Subject: Shoreline Exemption Permit, Pump Station 25 – 4266 E. Mercer Way.

This is a written response to the review comments provided by the Community Planning and Development Department regarding the application for the Shoreline Exemption Permit, SHL23-002, for Pump Station 25 located at 4266 E. Mercer Way .

PUMP STATION 25 - 4266 E MERCER WAY

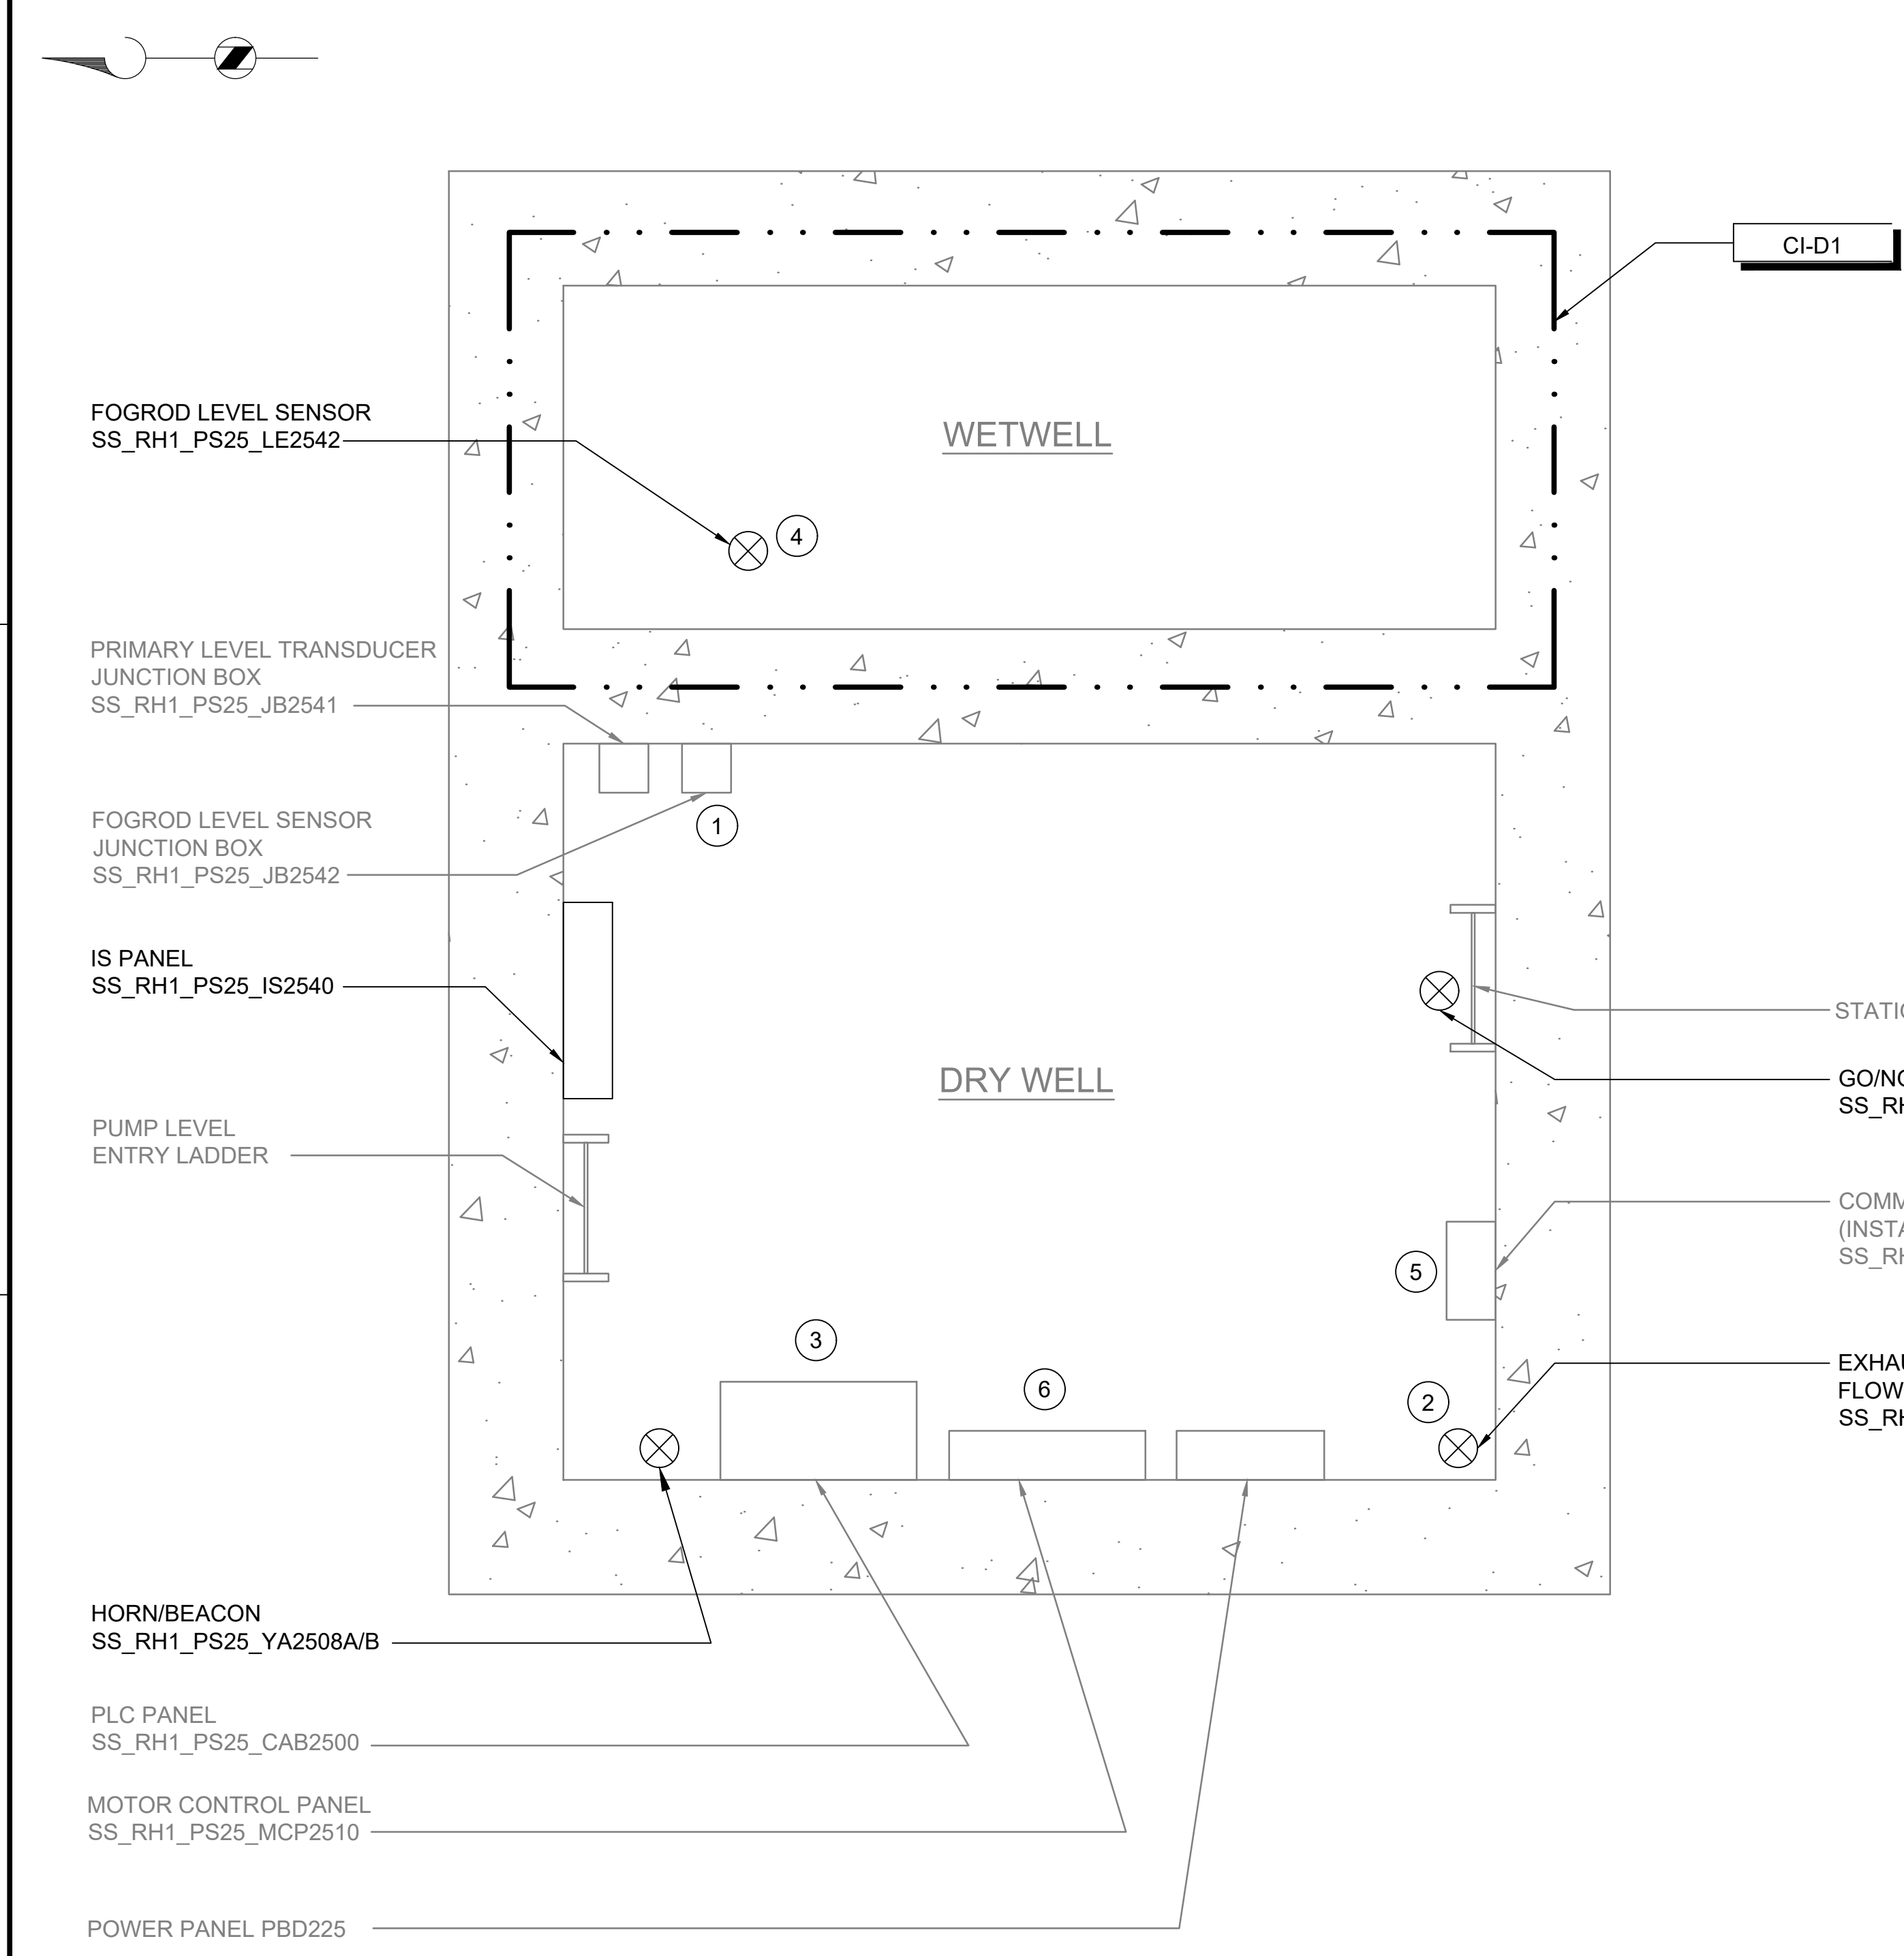
- a. Provide address of all pump stations on plans

Response: *The address for the pump station has been added to Development Plan, Instrumentation Drawing page 1. The address was also included in the aerial photo of the pump station.*
